From: Martyn White
Sent: 19 October 2018 09:31
To: Planning.Responses
Subject: EG/64/18

EG/64/18

DATE	JULY 2018	DRAWN	TW
DRAWING NUMBER	17123-03	REVISION	*

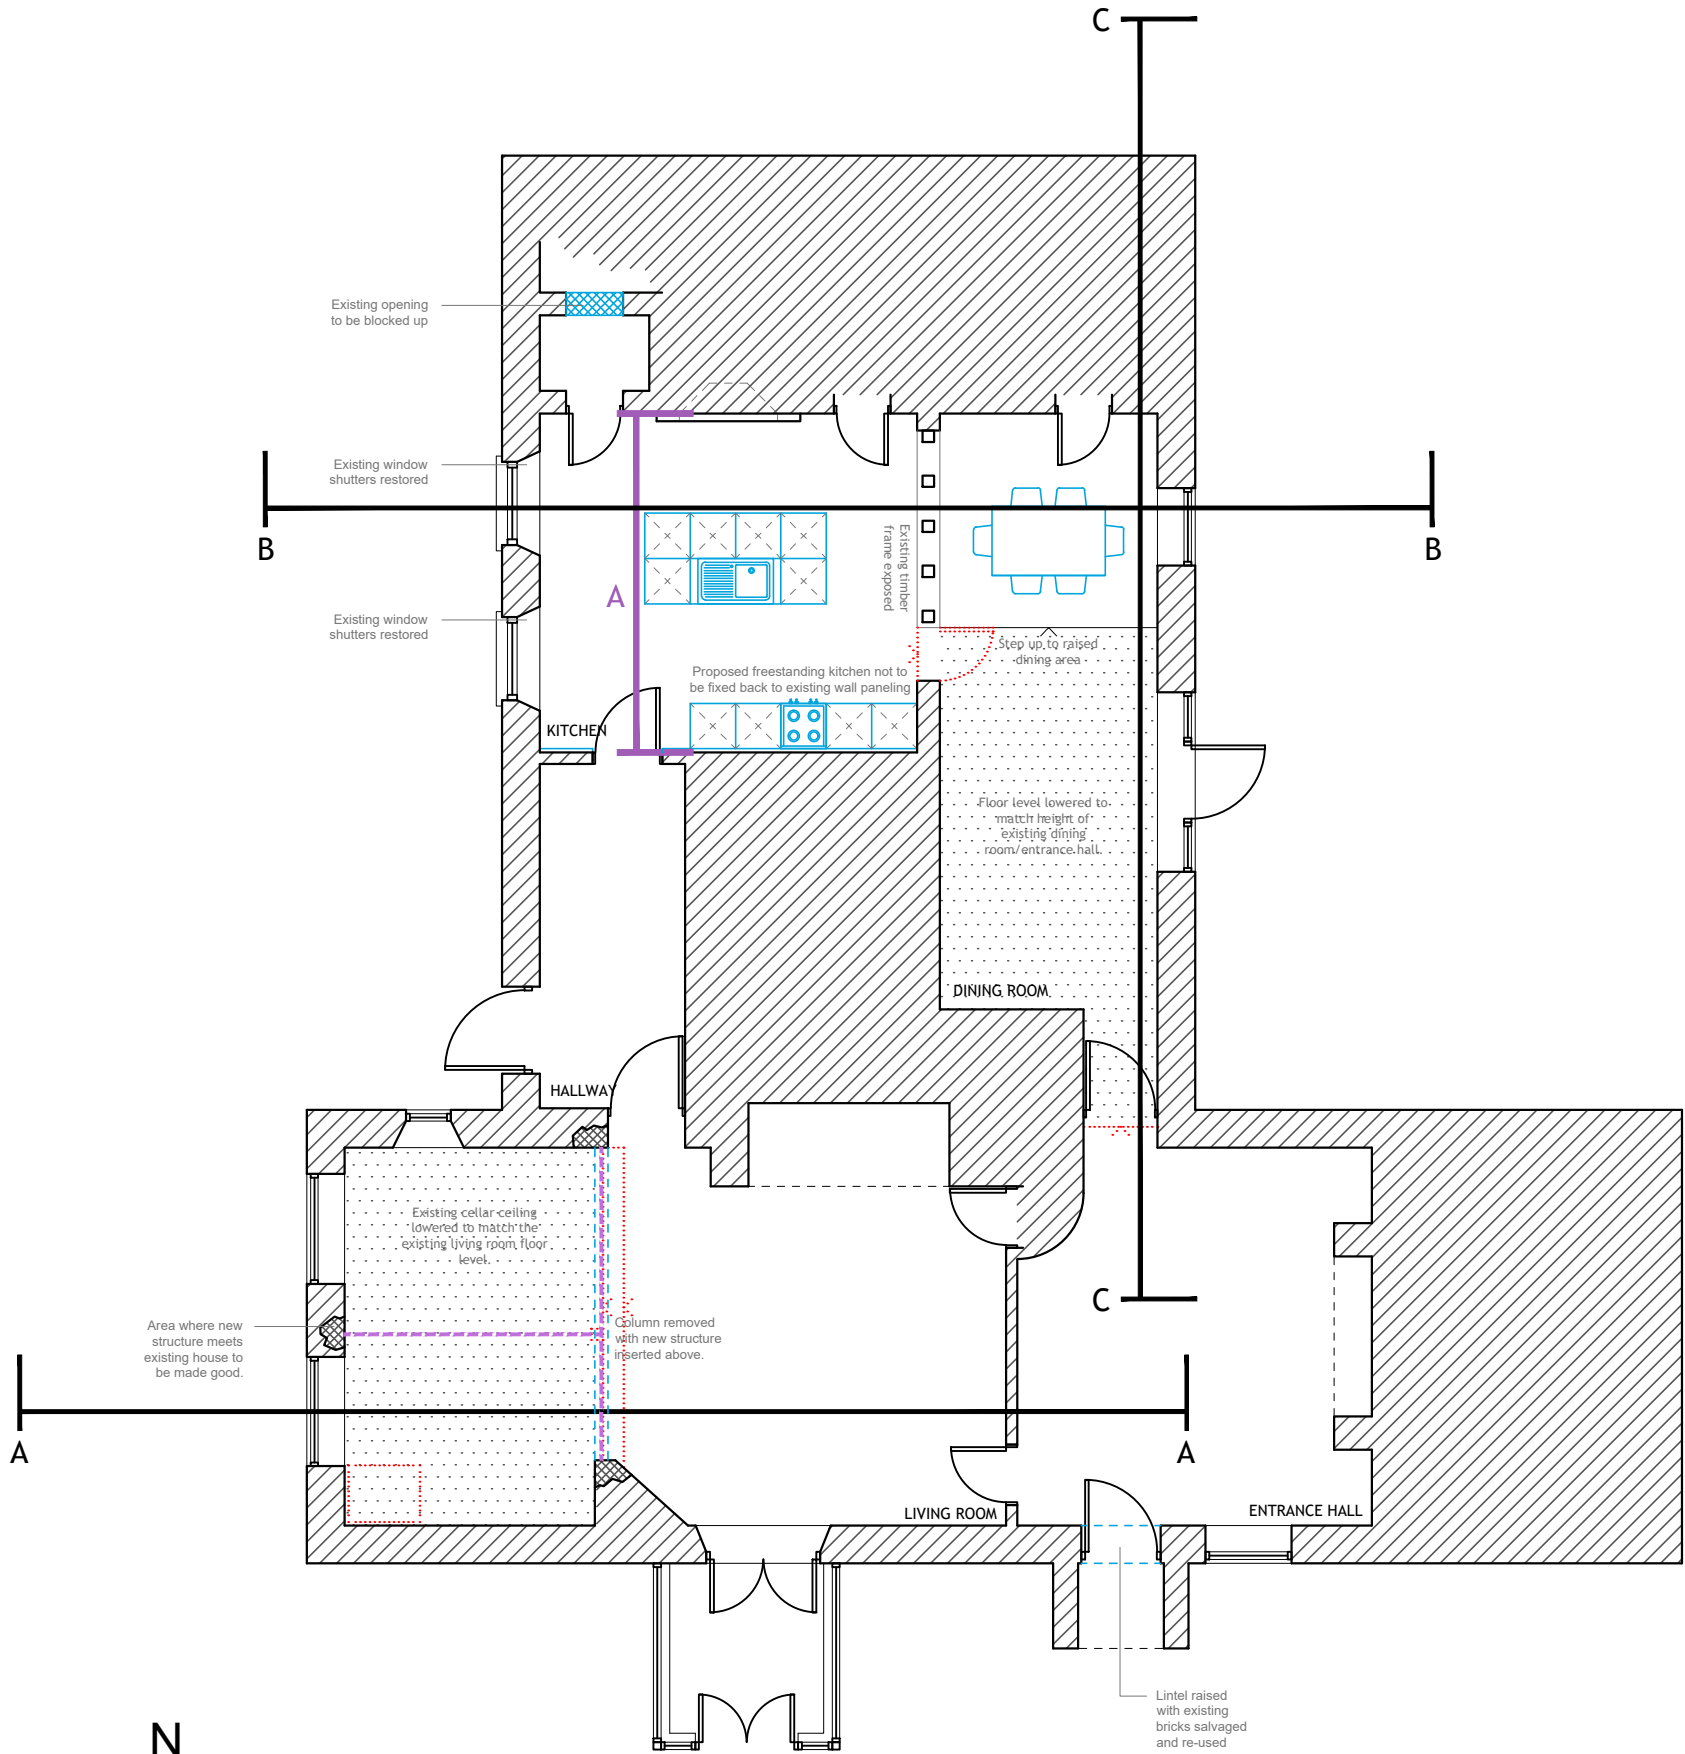
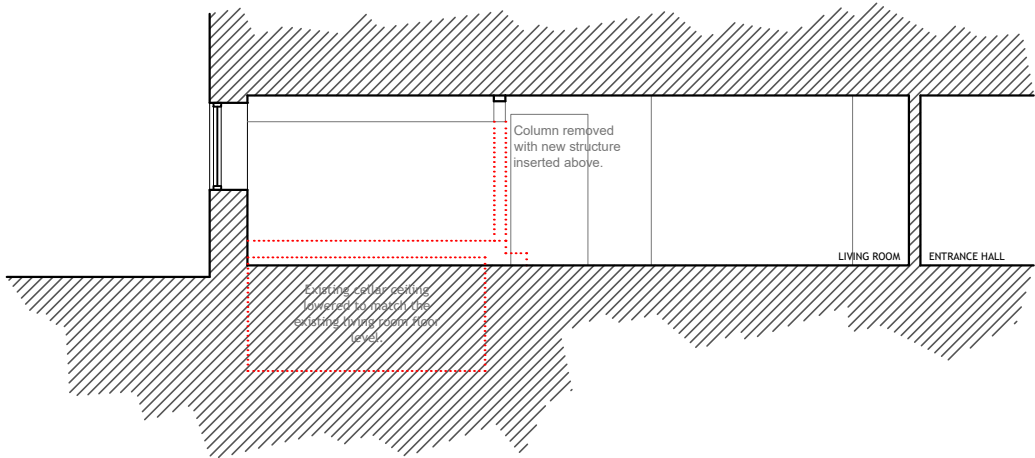
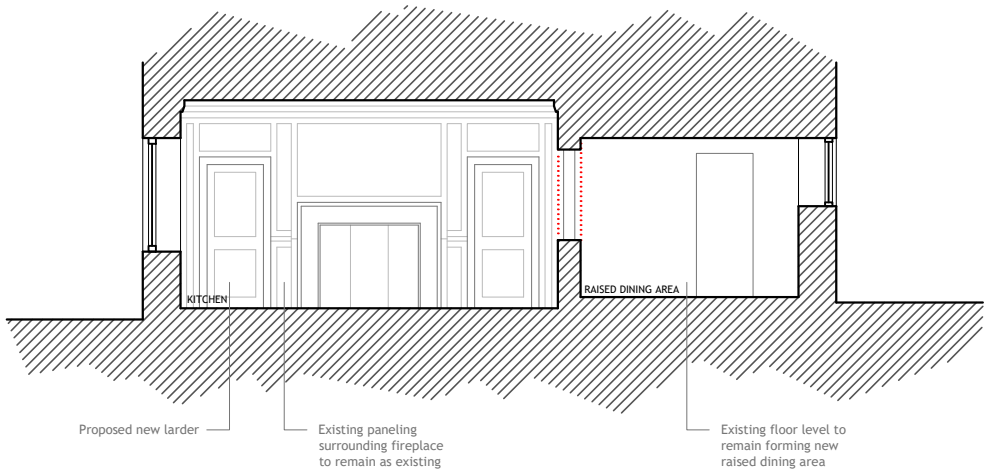
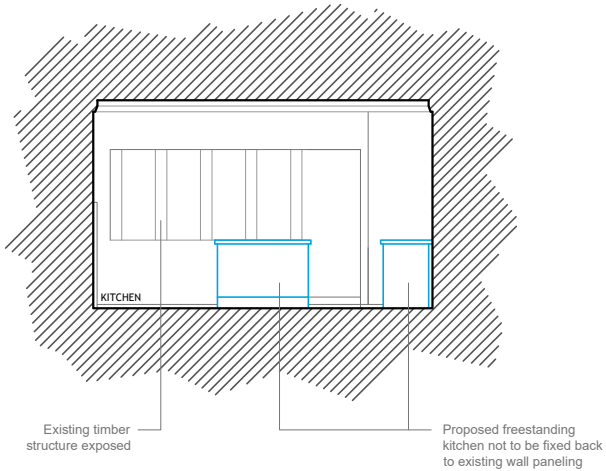
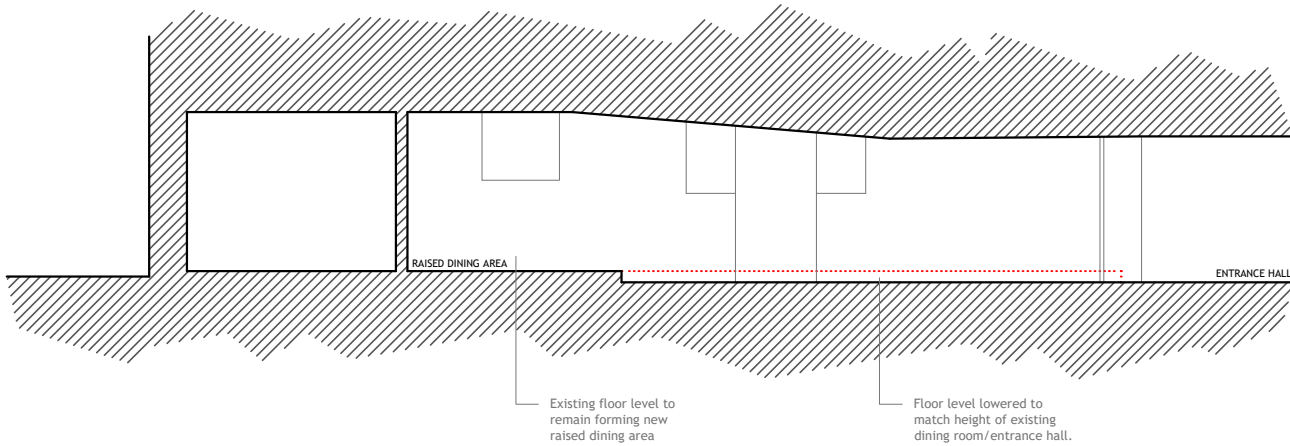
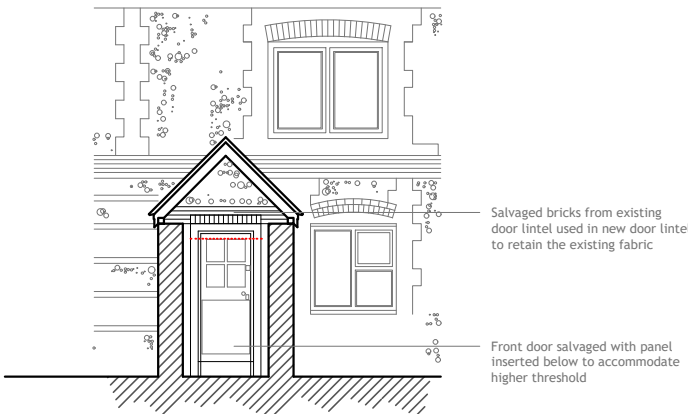
Cellar: the proposal is to return the floor to the original height so that it reflects the rest of the room. Such a proposal is acceptable as it allows the room to be fully used, and restores it more to its previous appearance.

Kitchen/dining room: this proposal allows for the main structural element of the property to remain, whilst allowing the two rooms to be linked. All of the proposed kitchen cabinetry should be free standing so that it does not affect those walls with panelling. The creation of a new larder is also considered to be acceptable.

Kitchen floor: there is a mixture of levels in the property. The proposal will allow for the room to be fully used. I should stress that I am not a structural engineer, and I cannot comment on the impact of the proposed works on the structure of the building.

Front door lintel: the proposal to raise the height of the door is acceptable, as previous alterations have taken place at this point. All of the bricks that are removed should be re-used at the property. I support the retention of the front door, which should be sensitively adapted.
